CITY OF ALBUQUERQUE

May 11, 2018

RE: **Utility Trailer Sales**
8201 Daytona Rd NW
Grading Plan Stamp Date: 4/30/18
Drainage Report Stamp Date: 4/30/18
Hydrology File: K09D026B

Based on the information provided in your submittal received on 5/8/18, the grading plan and drainage report cannot be approved until the following are addressed:

ENGINEER'S SEAL VINCENT P. CARRICA P.E. #16212	UTILITY TRAILER SALES ALBUQUERQUE NM GRADING AND DRAINAGE PLAN	DRAWN BY LA
	DATE 4/20/2018 2017041-GRADING	SHEET # C2 JOB # 2017041

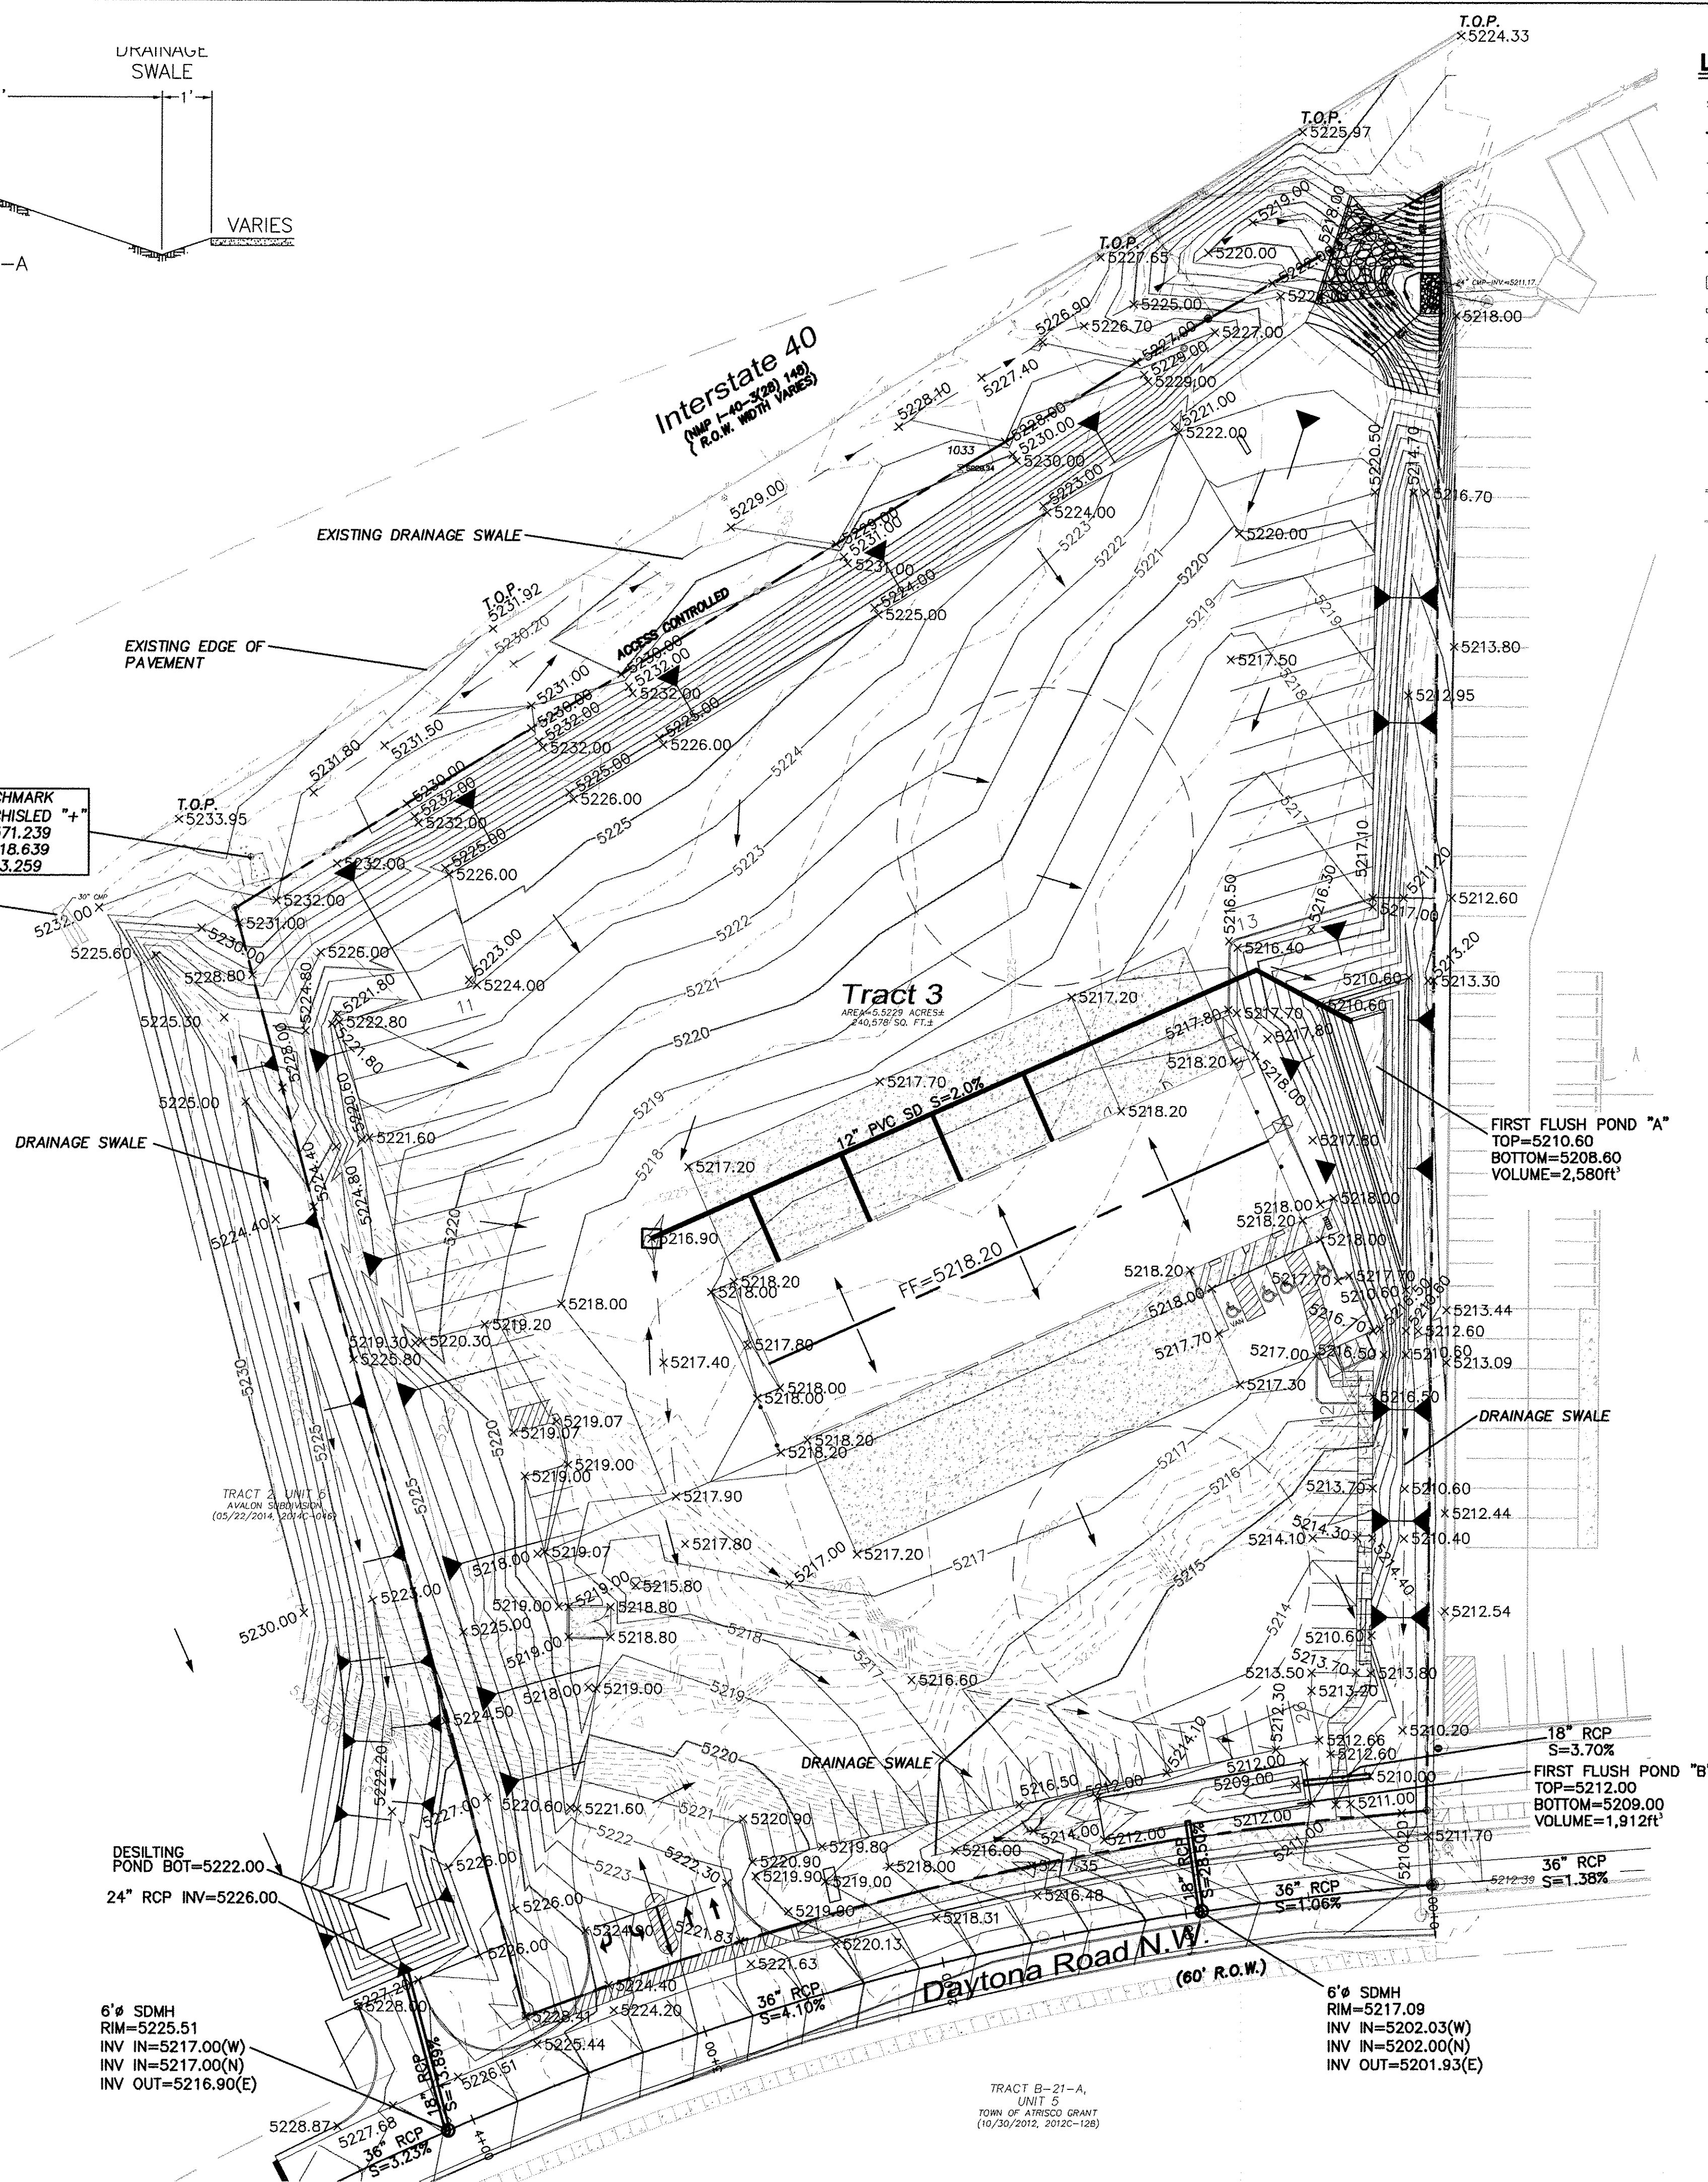
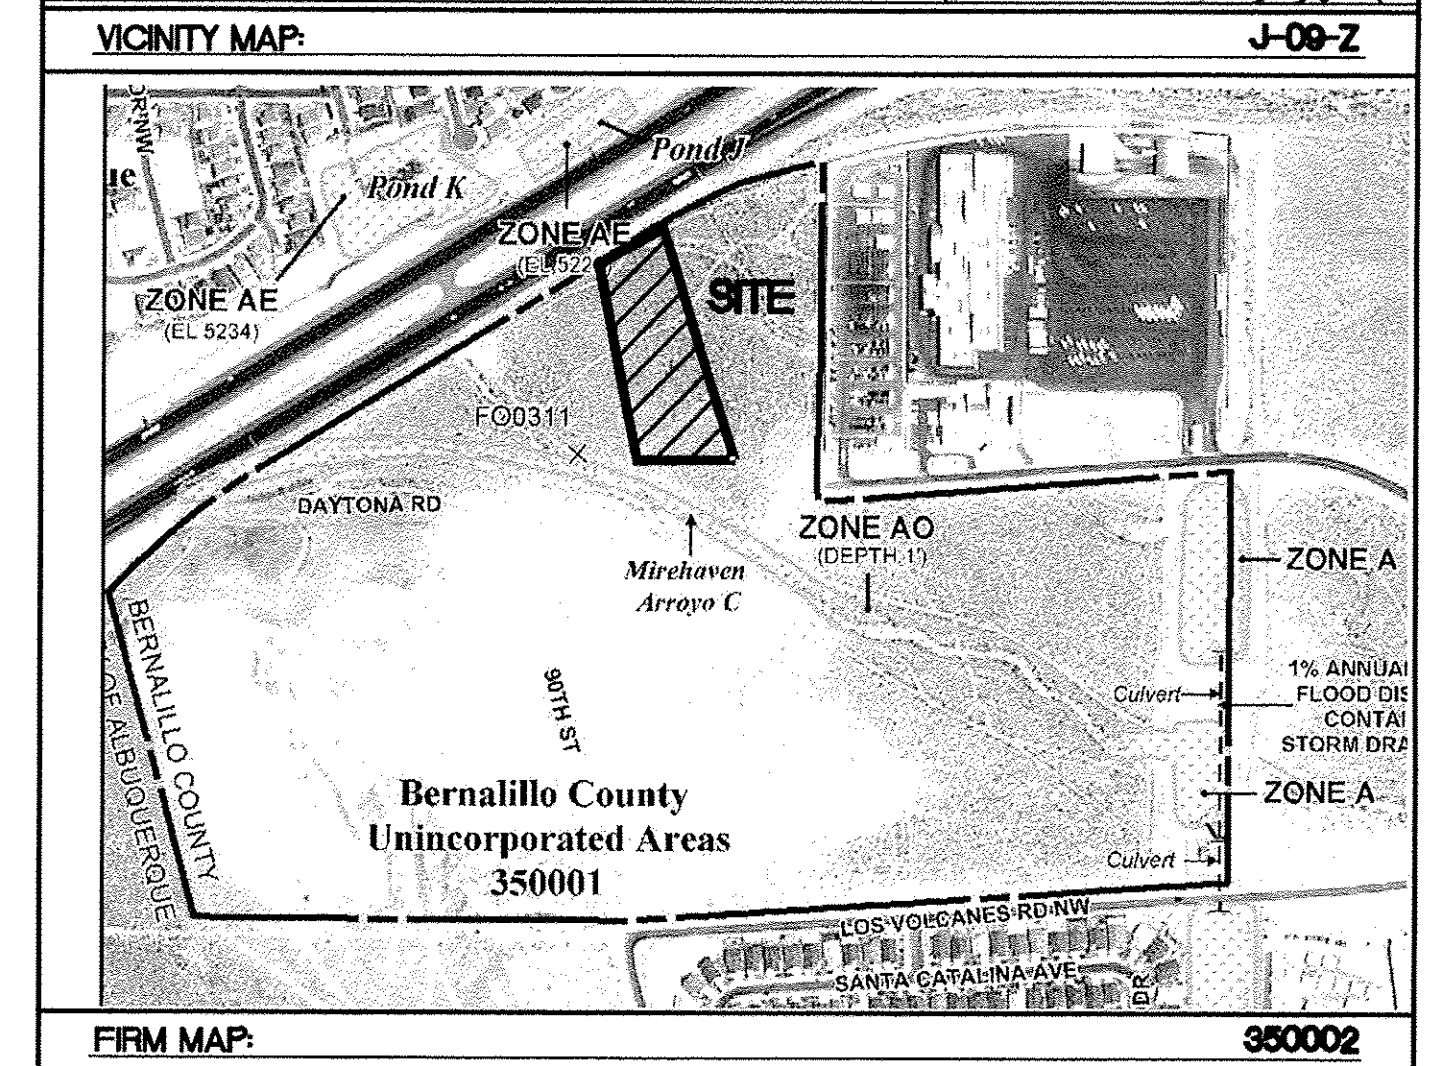
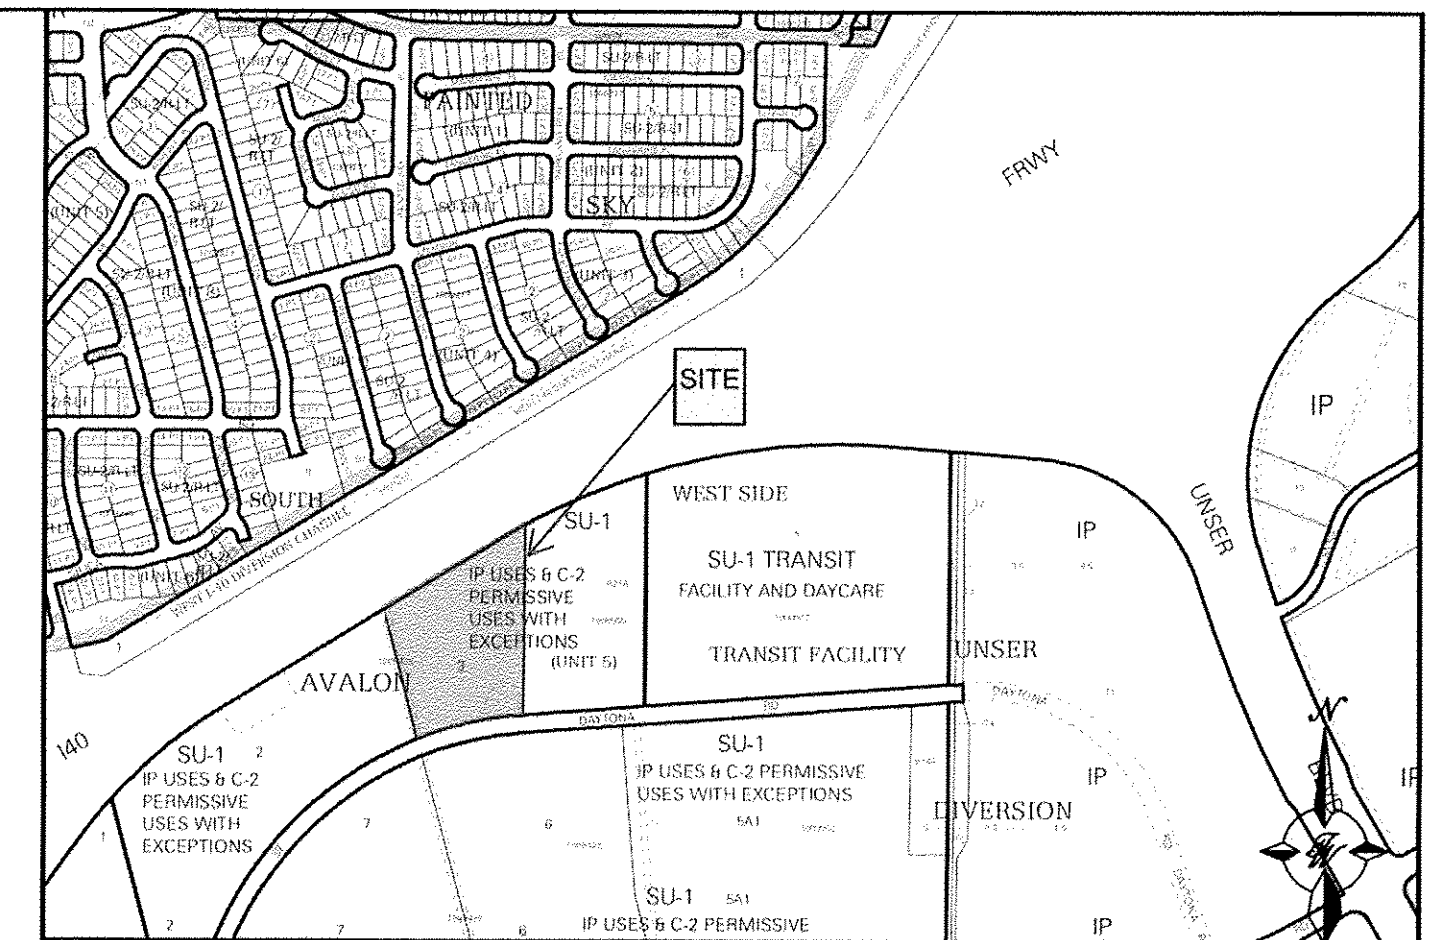
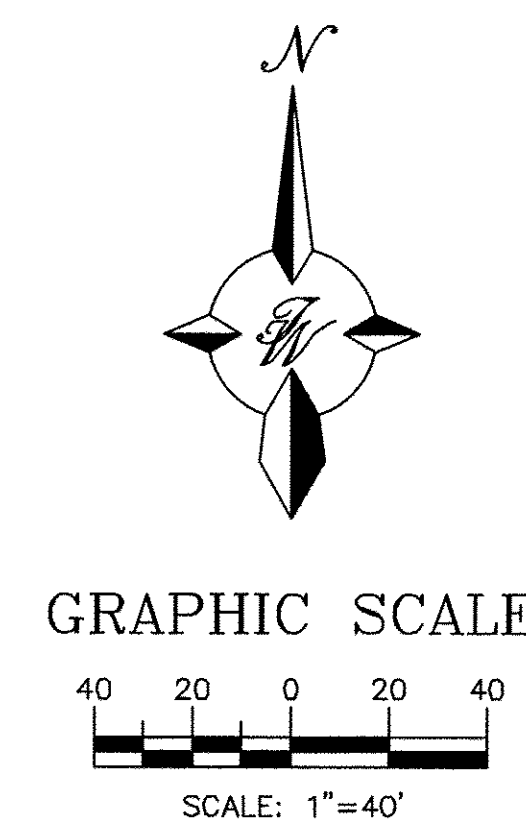
1. There may be a need for additional inlets in Daytona to contain future developed flows in the street. Provide street capacity analysis in Daytona. You may assume the subject site as discharging directly into the storm drain as you've proposed; however the upstream contributing basins will need to be assumed as discharging to the street.

2. Include inlet protection for the two new RCP stubouts to keep floatables and sediment from washing into the storm drain (ported riser or similar).
3. Provide written permission from the adjoining property (Tract 2) for work on their property. A public drainage easement and an agreement and covenant are required for the maintenance of the realigned swale and the pond, as these facilities convey public water.

4. Provide a public drainage easement and an agreement and covenant for the riprap and gabions in the NE corner.
5. Include project datum.
6. This grading plan includes existing and proposed contours and spot elevations showing regrading of the I-40 bar ditch and grading at both median drain outfalls. Provide written concurrence from NMDOT D3 Drainage that this project can proceed. All work in NMDOT's ROW will need to be included on the infrastructure list.

7. The upstream offsite basins need to be delineated and included in your analysis. Demonstrate that the diversion swales are adequately sized to convey these flows from the I-40 ROW to the receiving storm drain along Daytona.
